# CITY OF ALBUQUERQUE

**RE: Hampton Inn (Holly Ave)  
Grading Plan and Drainage Report  
Engineer's Stamp Date – 4-22-2016  
Hydrology File: C18D073B**

DRB Project Number: 1010357  
Holly Hampton Inn

DRB Project Number: 1010357 Hearing Date: 4/20/2016  
Project: Hampton Hotel Agenda Item No: 3

GRADING AND
DRAINAGE PLAN

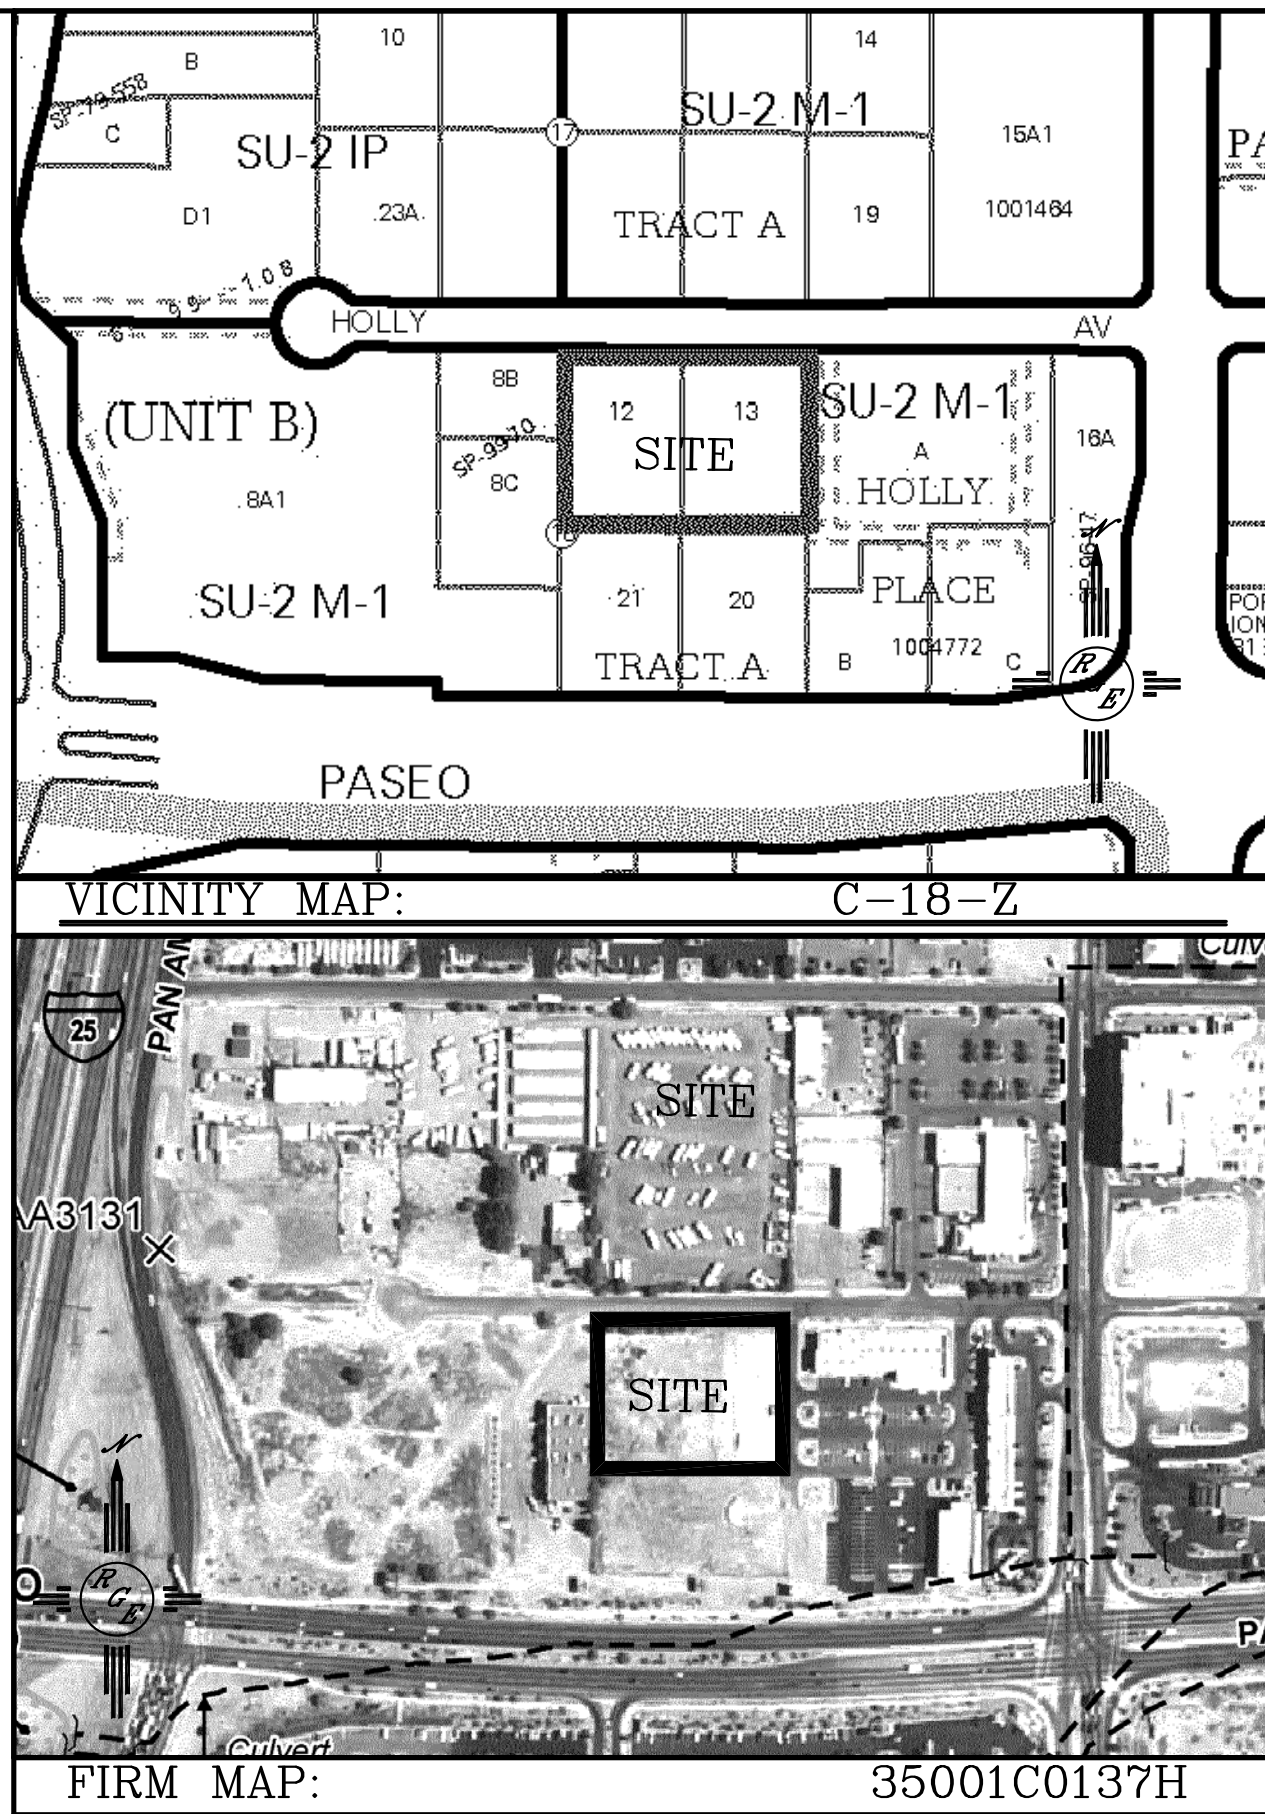
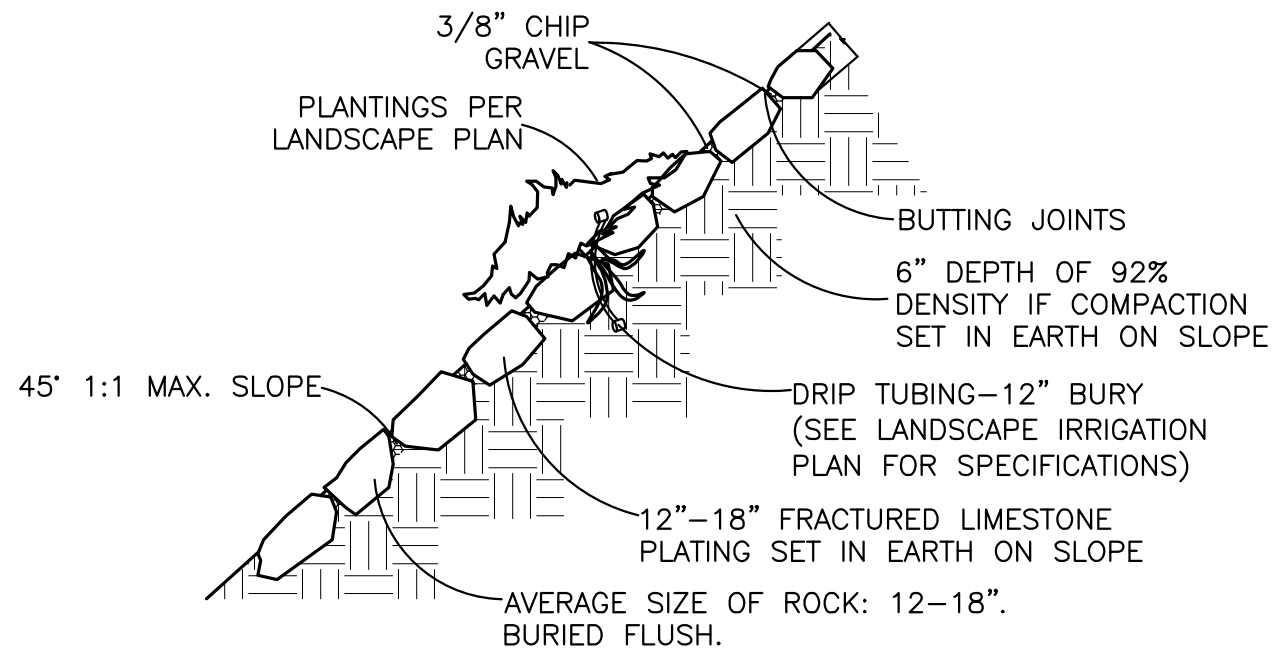
- Hydrology has an approved grading plan, and drainage report (stamp date 11-18-15), for Site Plan approval.
- The drainage report states that this site receives unland flows. A private cross lot drainage easement may be needed. **We are adding blanket cross lot drainage**
- Tract A was to discharge thru a shared access drive along the eastern edge, but it appears from the grading that it now discharges thru this site. Provide supplement to drainage report showing how much flow will be entering from Tract A, and how it will discharge. **Flows are accepted. passed thru north drive isle onto holly**
- Lots 21 and B1 both discharge thru this site. Was swale was sized to accommodate these flows? Report needs supplement information addressing offsite flows.

**We have added channel section calculations**
